From: Annette Walker [REDACTED]
Sent: 27 May 2021 12:36
To: Finlay Gardner <Finlay.Gardner@arun.gov.uk>
Subject: Planning Application BE/59/21/PL

I wish to make an objection to a planning application. Unfortunately I've been unsuccessful in accessing the necessary form. Please would you submit the below objection for the Planning Application BE/59/21/PL for 339 Chichester Road PO21 5AN

SITE PLAN - SHOWING VISIBILITY SPLAYS
1:500 SCALE (at A3)

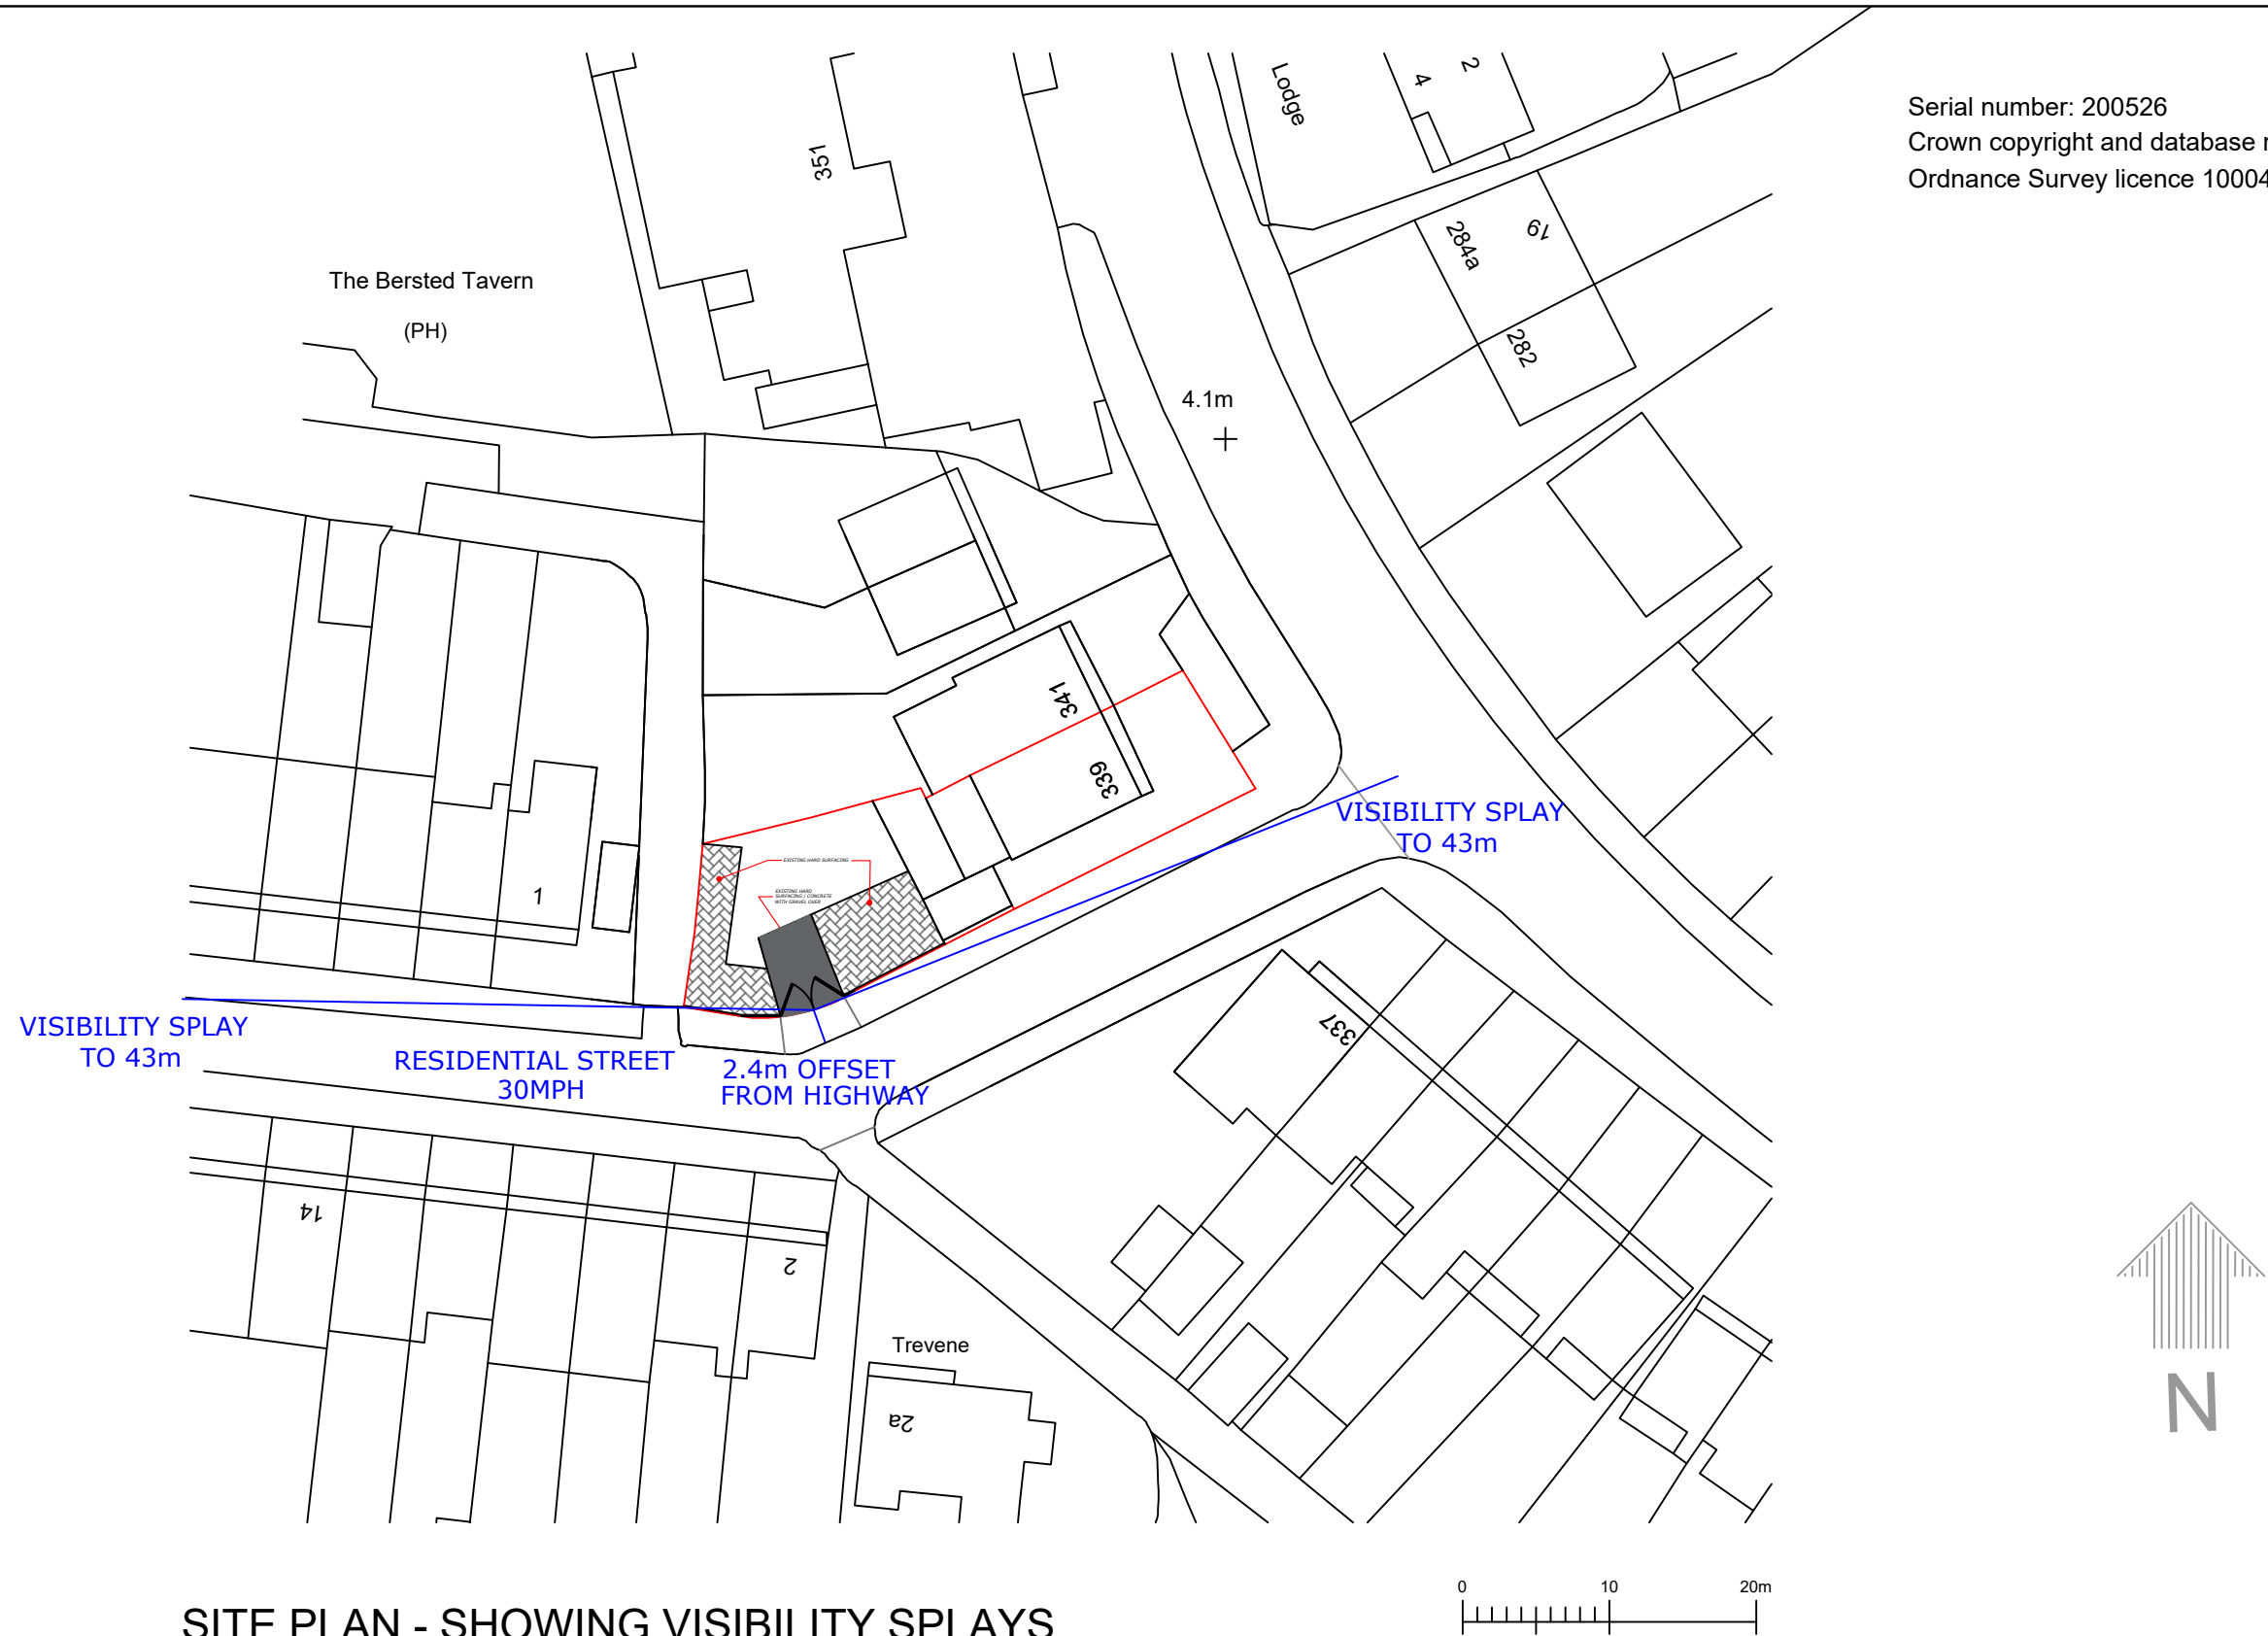
The proposed application is on a curve. Where the traffic off the Chichester Road comes into Bedford Ave too often at an increased speed. Together with the parked vehicles and traffic from the other direction is an accident waiting to happen.

Bedford Ave is an already busy road with parked cars. The company vans and employees vehicles around No339 proposed back entrance limits visibility.
